Lisa & Neil Brooks
[REDACTED]
[REDACTED]

Submission to Planning Industry & Environment

Re: BLUE GUM COMMUNITY SCHOOL
Application No: SSD-10444

WE OBJECT TO THE PROPOSED DEVELOPMENT

Title
SITE AND ROOF PLAN

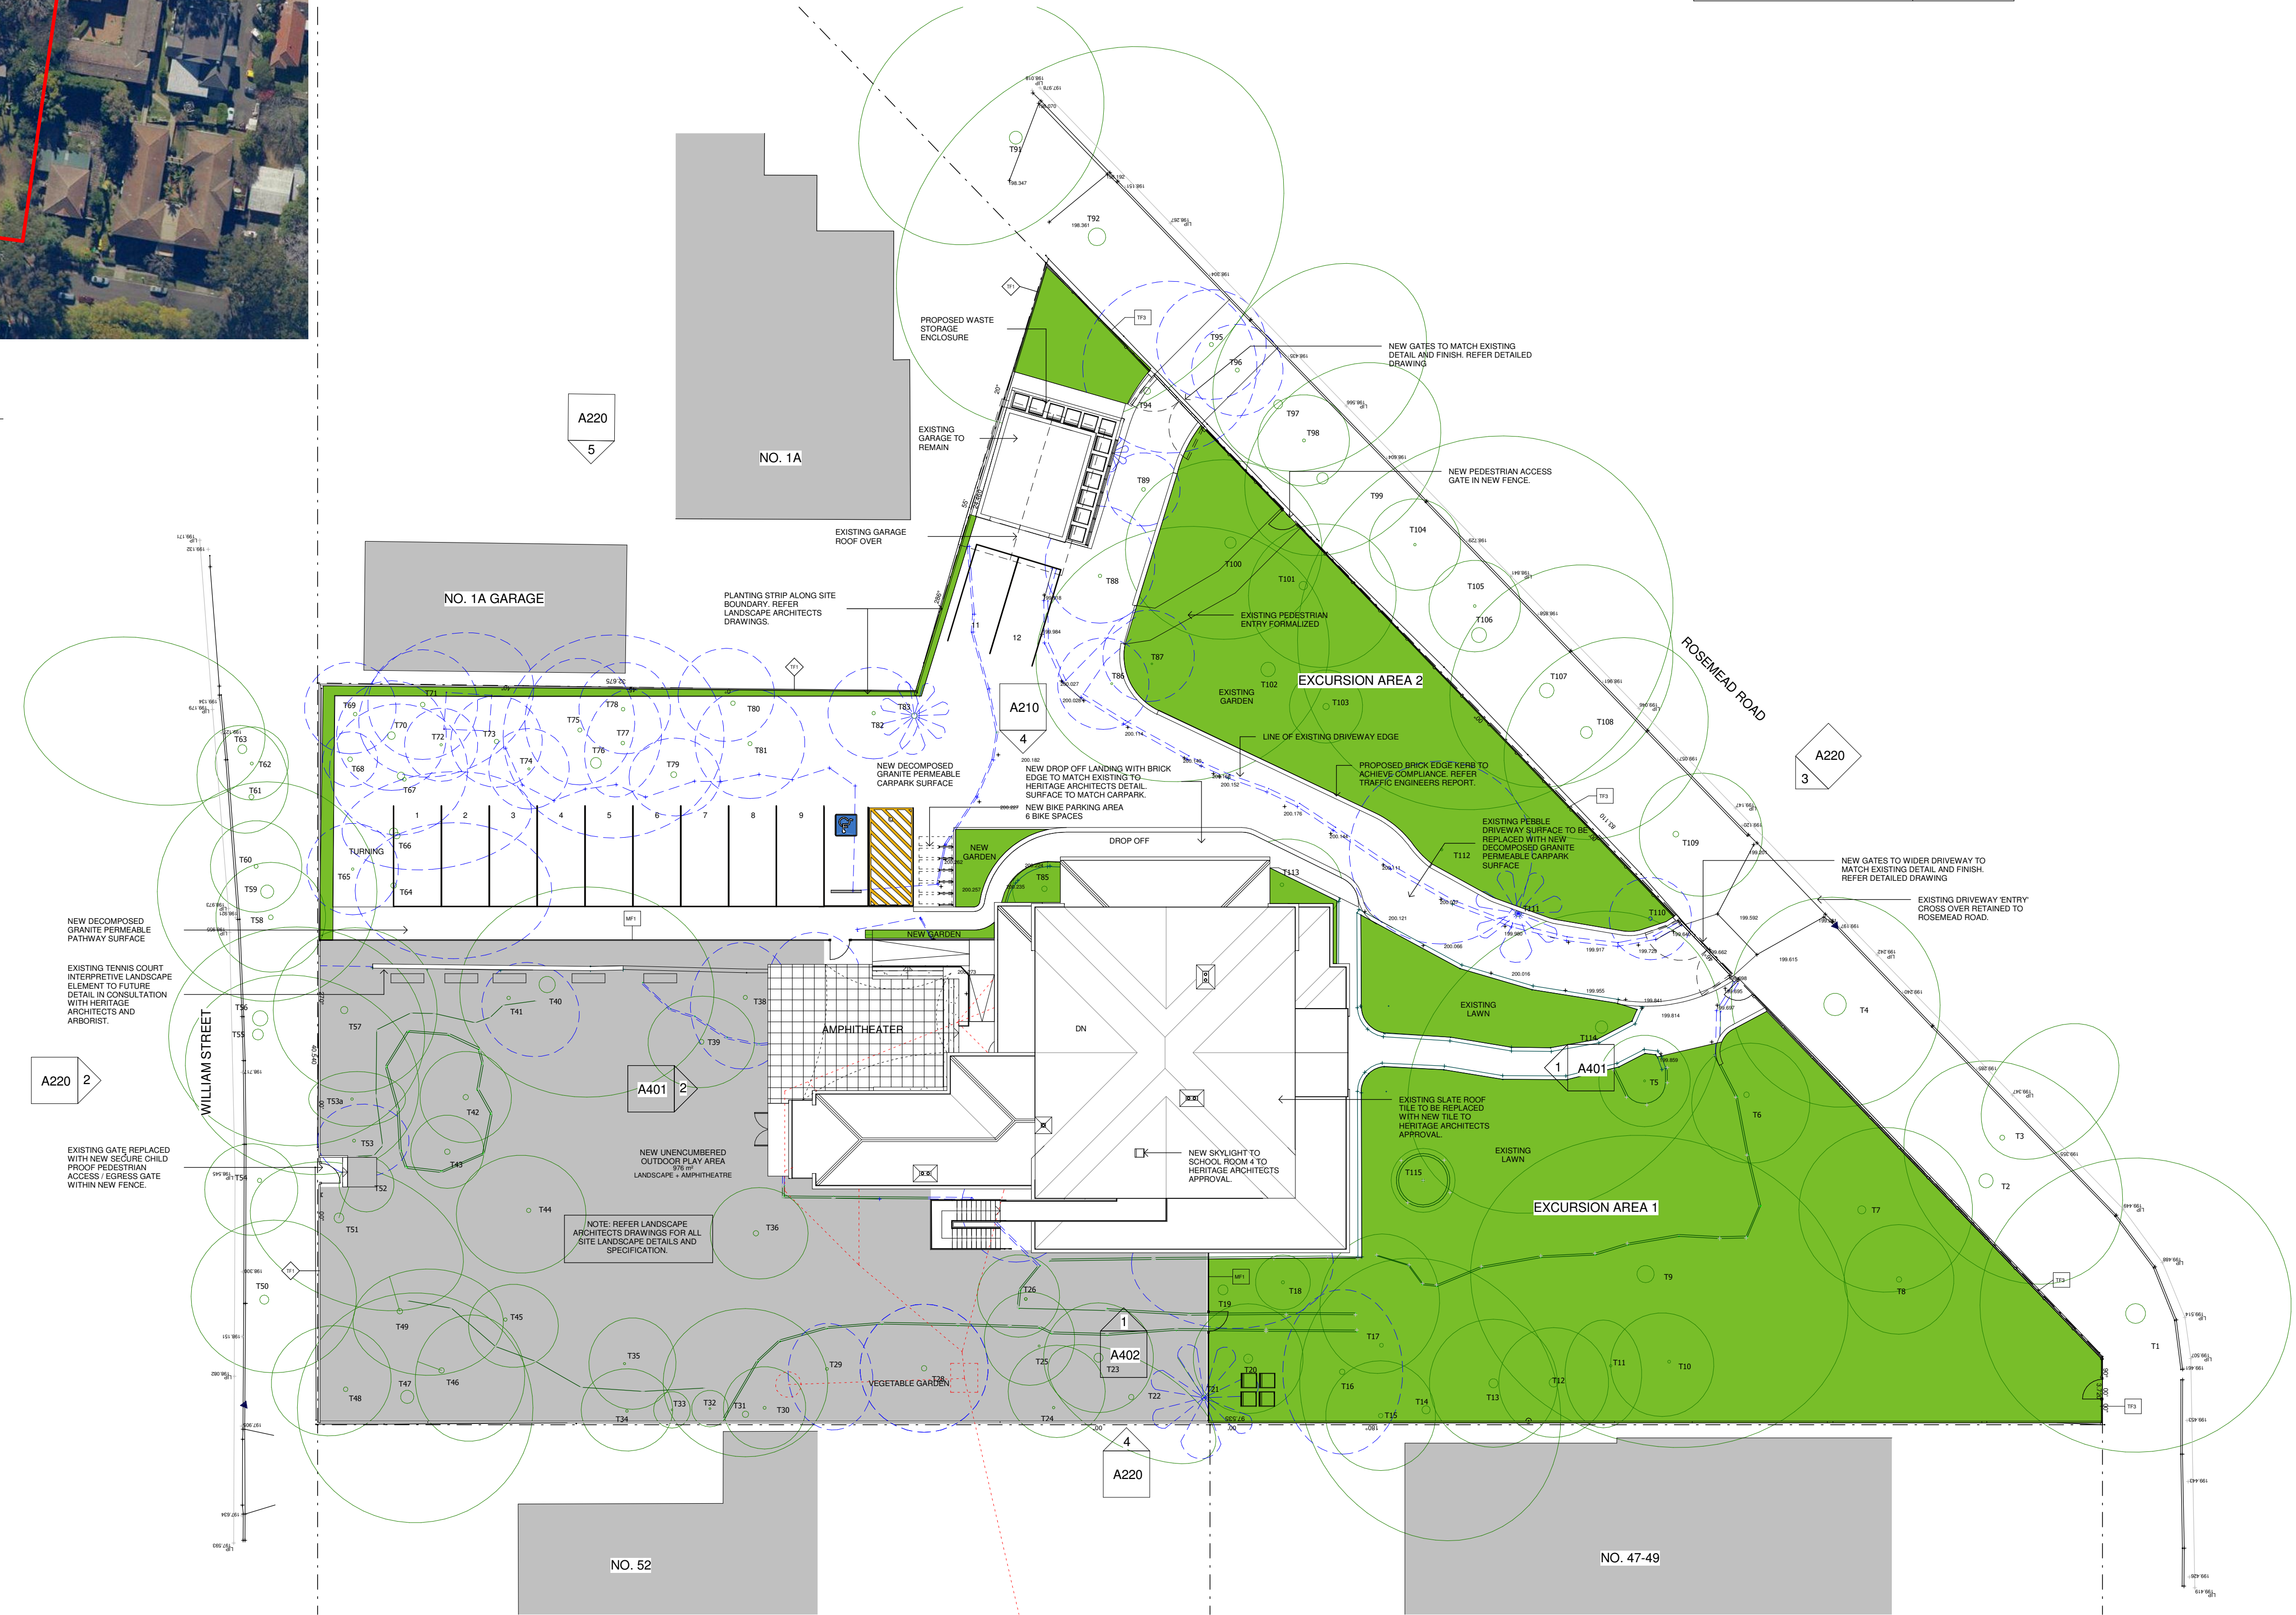
- A considerable number of trees are to be removed for this development for the provision of a carpark, driveway and brick paved area.
- Proposal of the owner "The removal of the giant birds of paradise in the front gardens is the most significant visual change that would occur as a result of the DA. Its removal will allow the widening of the driveway as well as ensuring more natural light reaches the front garden area. This change would also open a wide view of Mt Errington from Rosemead Road, a benefit identified by the Heritage Consultants. 20 trees would be impacted by the provision of access and car parking. 10 trees would be impacted by the extension of the driveway. 2 are affected by the brick paved area proposed, 1 by the new fire stair."

- No.14 Rosemead Rd were denied application to remove a couple of trees from the nature strip to provide driveway access to their garage. **Why should Mt Errington be granted permission to remove in excess of THIRTY (30) trees when it is a Heritage listed property and gardens?**

ELEVATIONS HOUSE

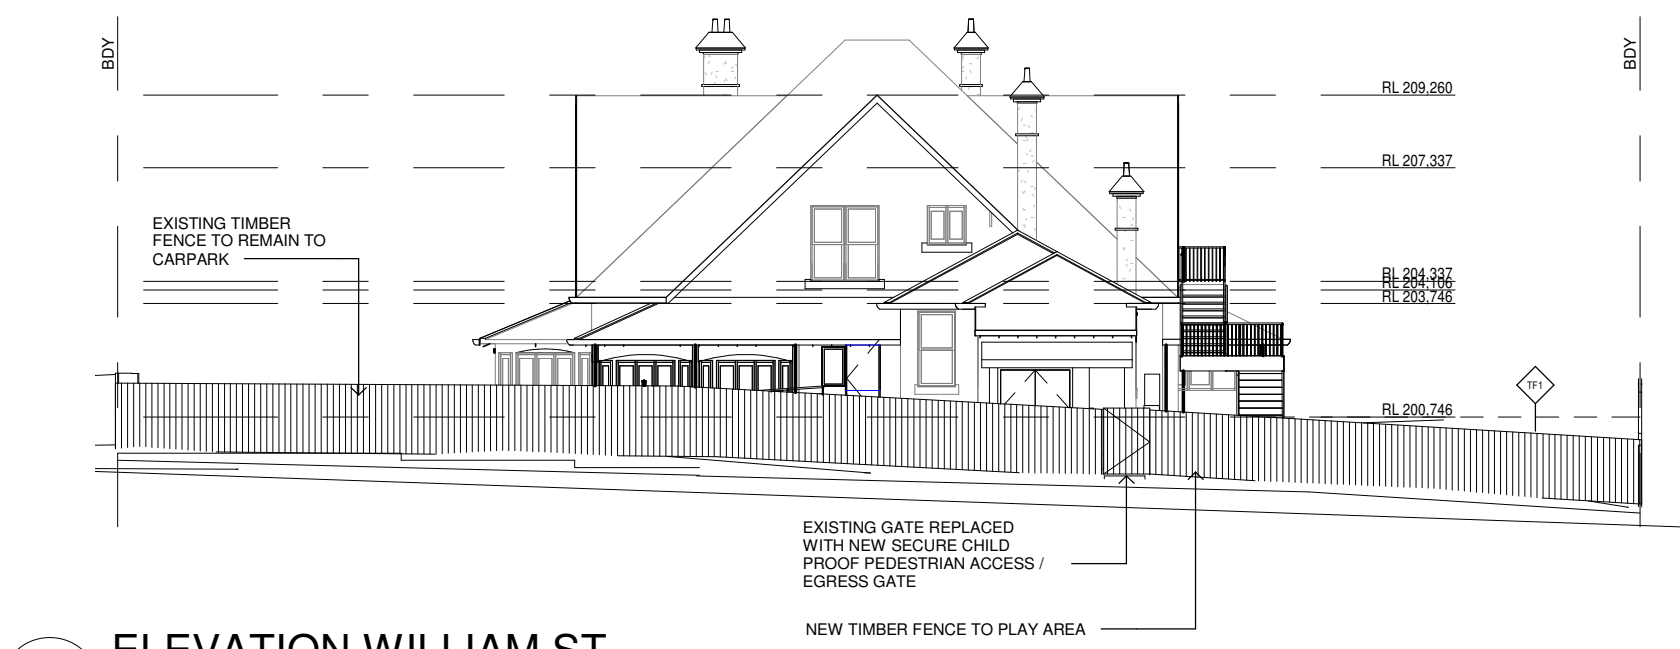
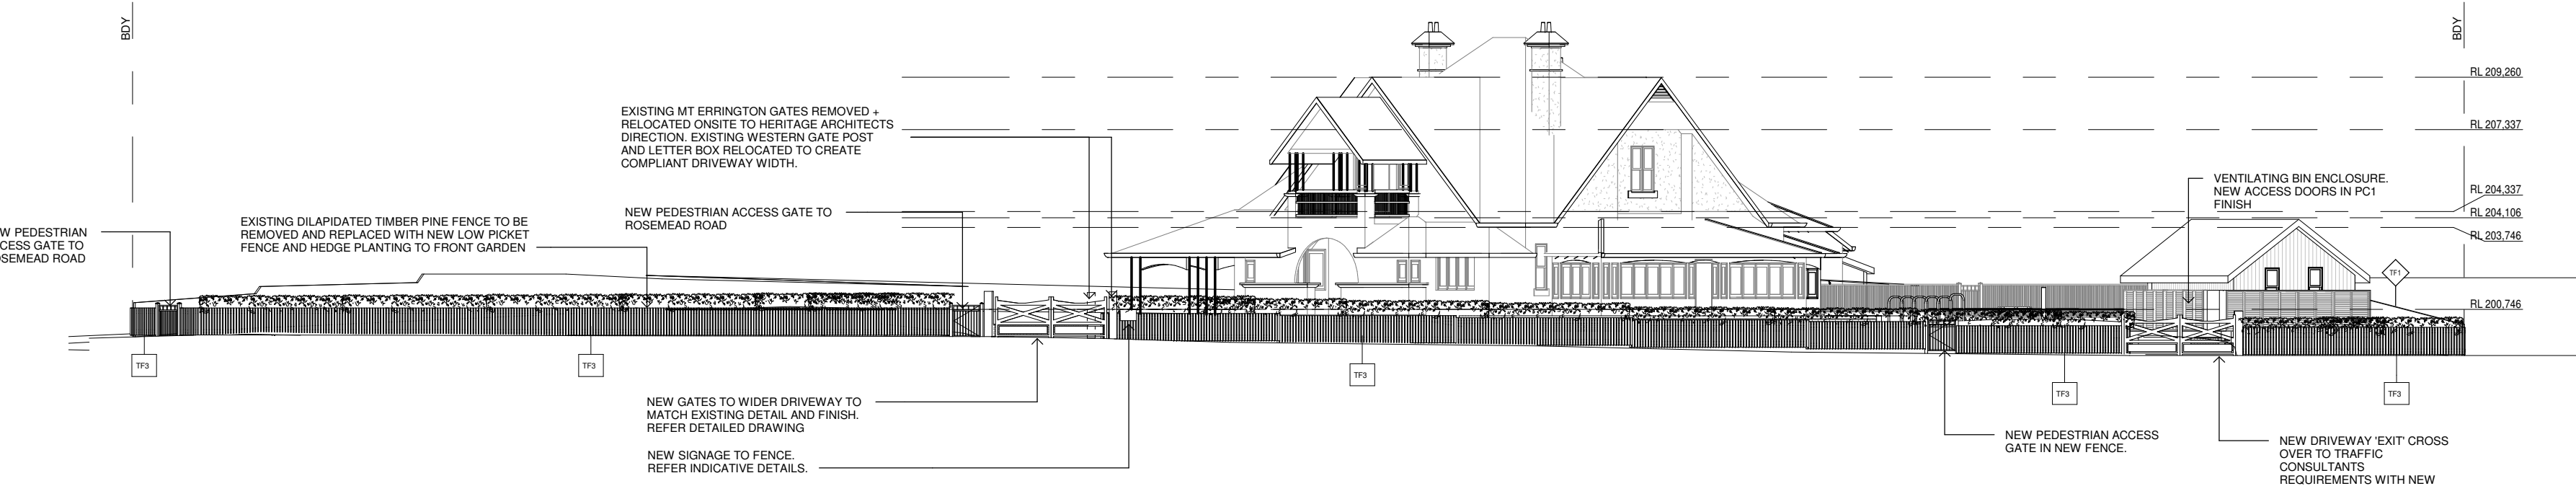
- William St (from Lisgar Rd) and Rosemead Rd have unrestricted parking on both sides of the streets leaving these streets ONE (1) x LANE for BOTH directions. Vehicles are parked up William St nearly to Rosemead Rd by people walking to Hornsby Station. The same in Dural St.

- Visibility is poor at both intersections of William/Rosemead and Rosemead/Dural and William St has TWO (2) areas where the road is narrowed (one is on the hill closest to Rosemead and has exceptionally poor visibility over the crest of the hill and vehicles are often parked where there are centre line dividers and ONE (1) lane each way.) In these instances to drive up or down William St you must drive on the opposite side of the road.
